**CITY OF PORTLAND, MAINE**  
**PLANNING BOARD**

November 3, 2003

RE: 191 Riverside Street

On October 28, 2003, the Portland Planning Board voted 5 to 0 (Malone abstained, Delogu absent) to approve the site plan for Maine Mall Motors at 191 Riverside Street. The Board voted on the following motions:

Title: LAYOUT AND LIGHTING PLAN

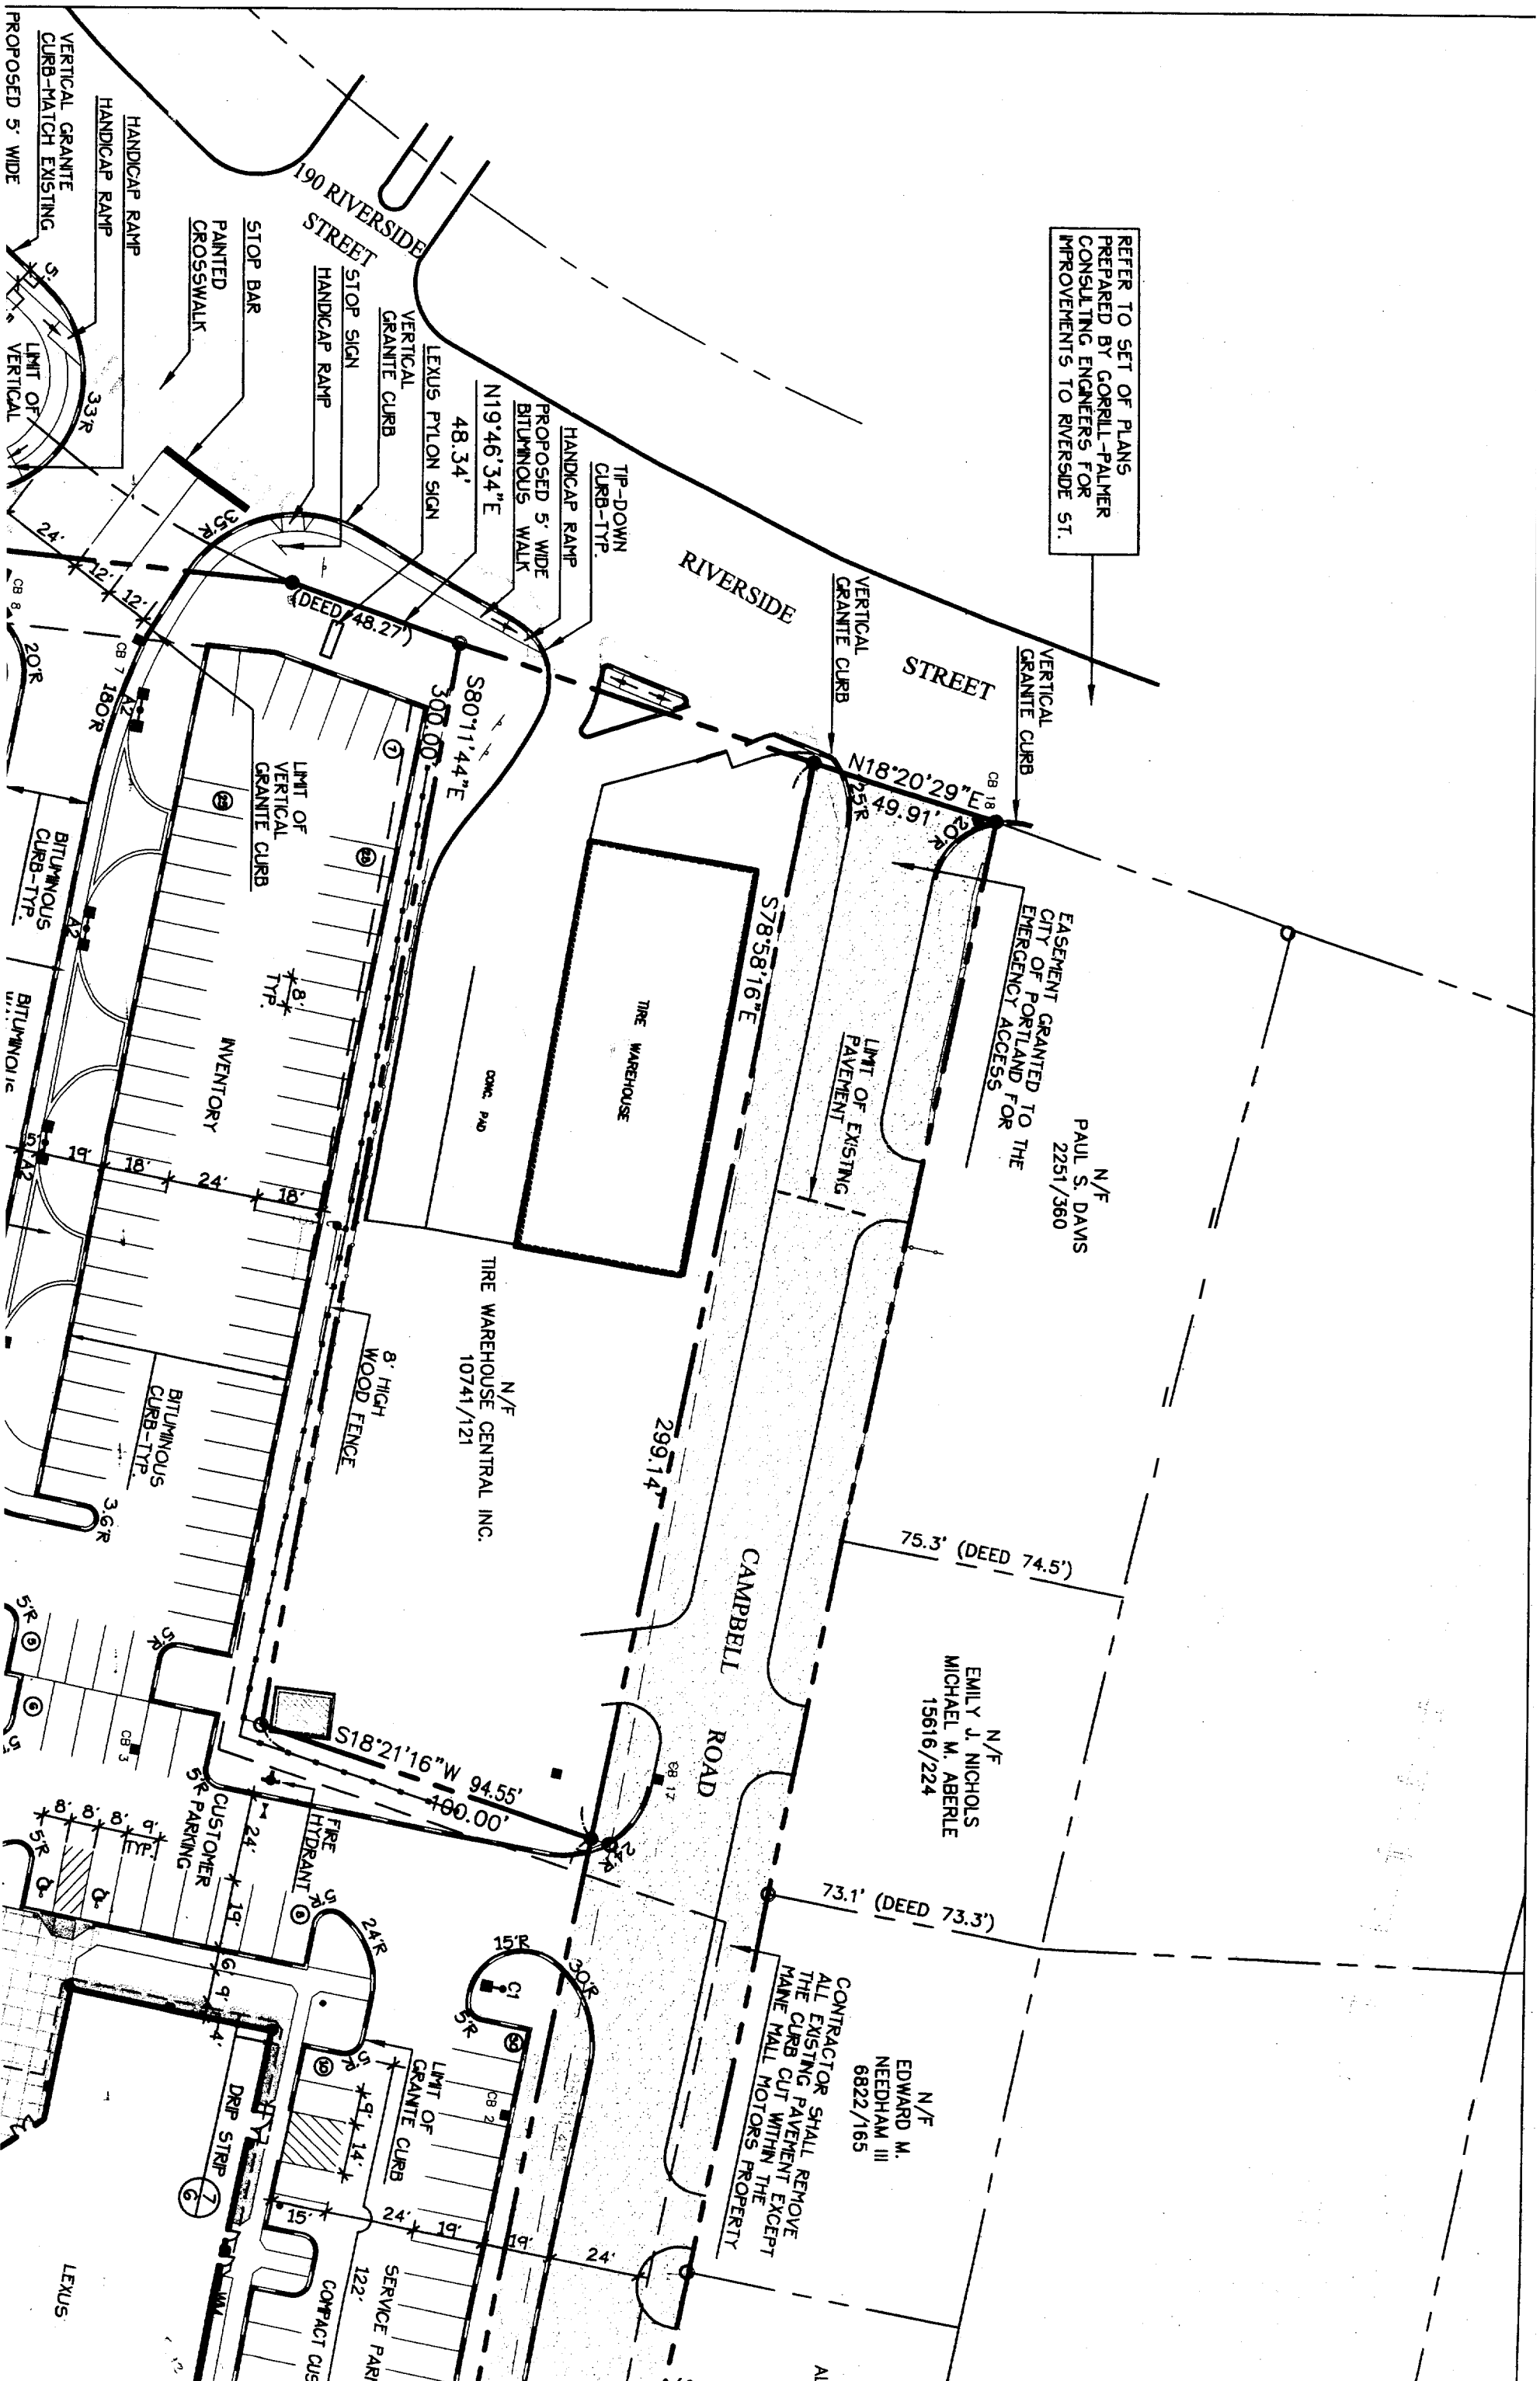
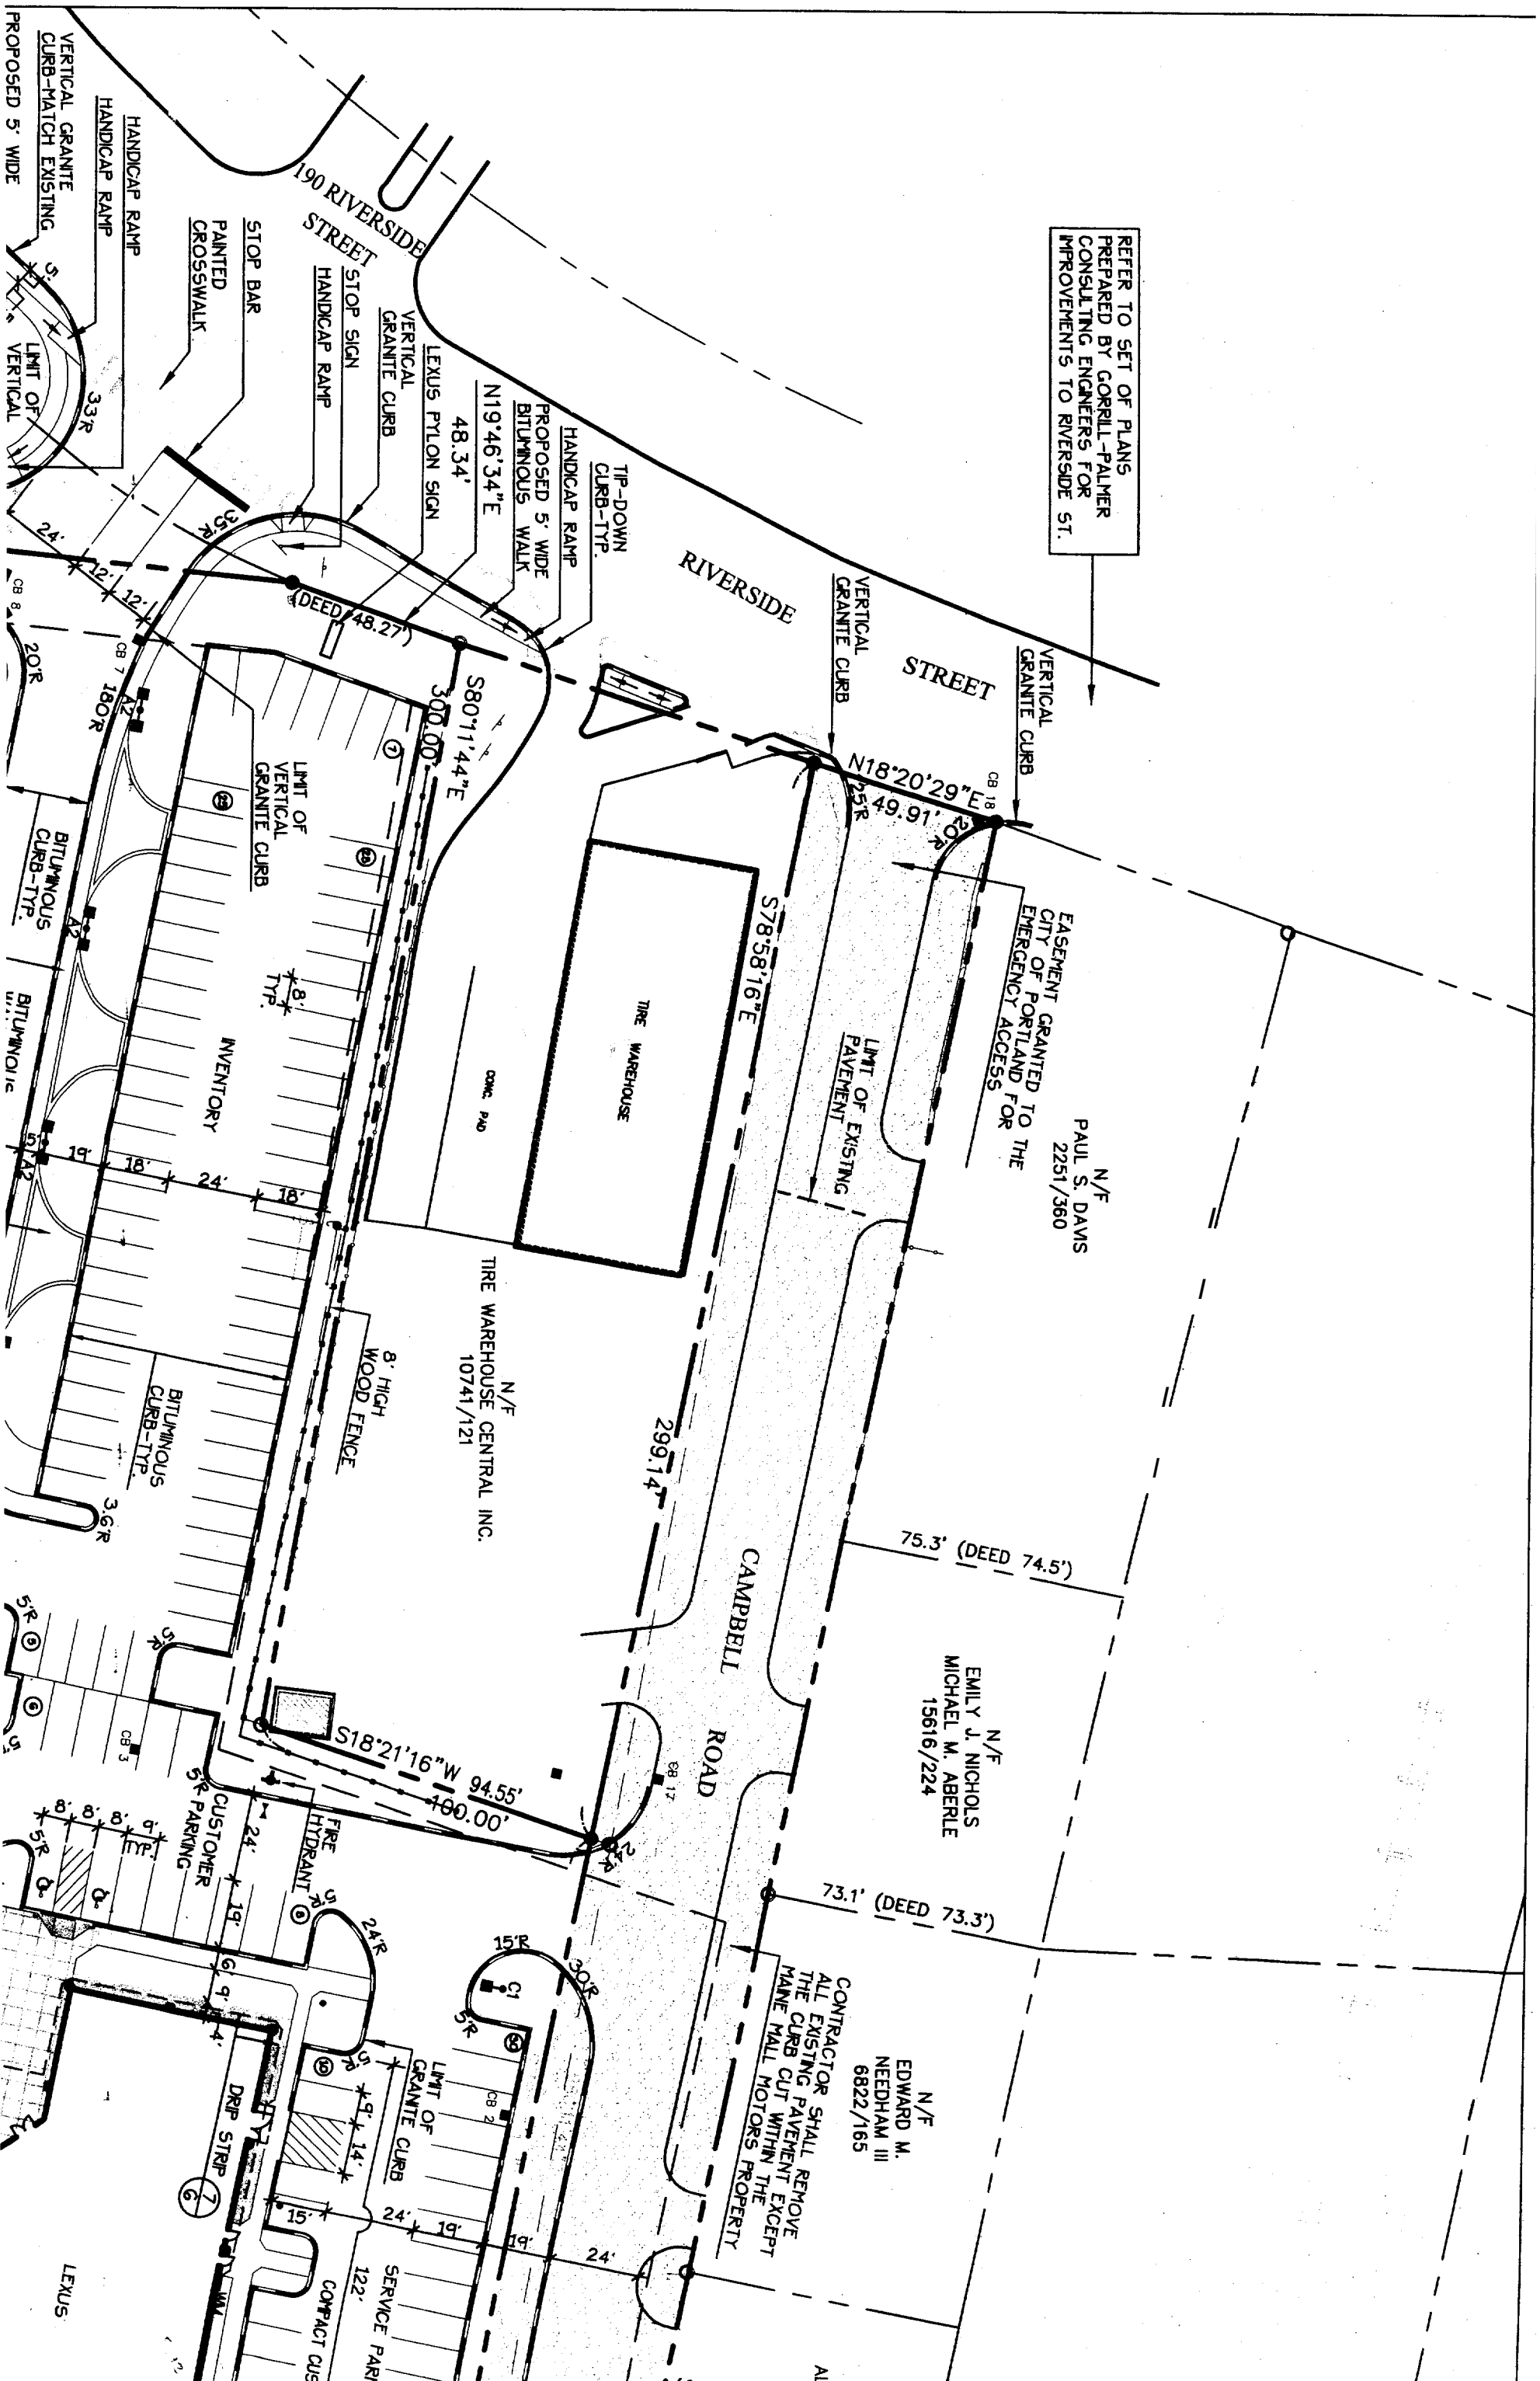
- ii. *That a revised lighting plan be provided for staff review and approval showing reduced light trespass at the property boundaries.*
- iii. *That an easement be provided, subject to the review and approval of City Corporation Council, that allows public access and maintenance of the section of Riverside Court that is proposed to be relocated onto the subject parcel.*
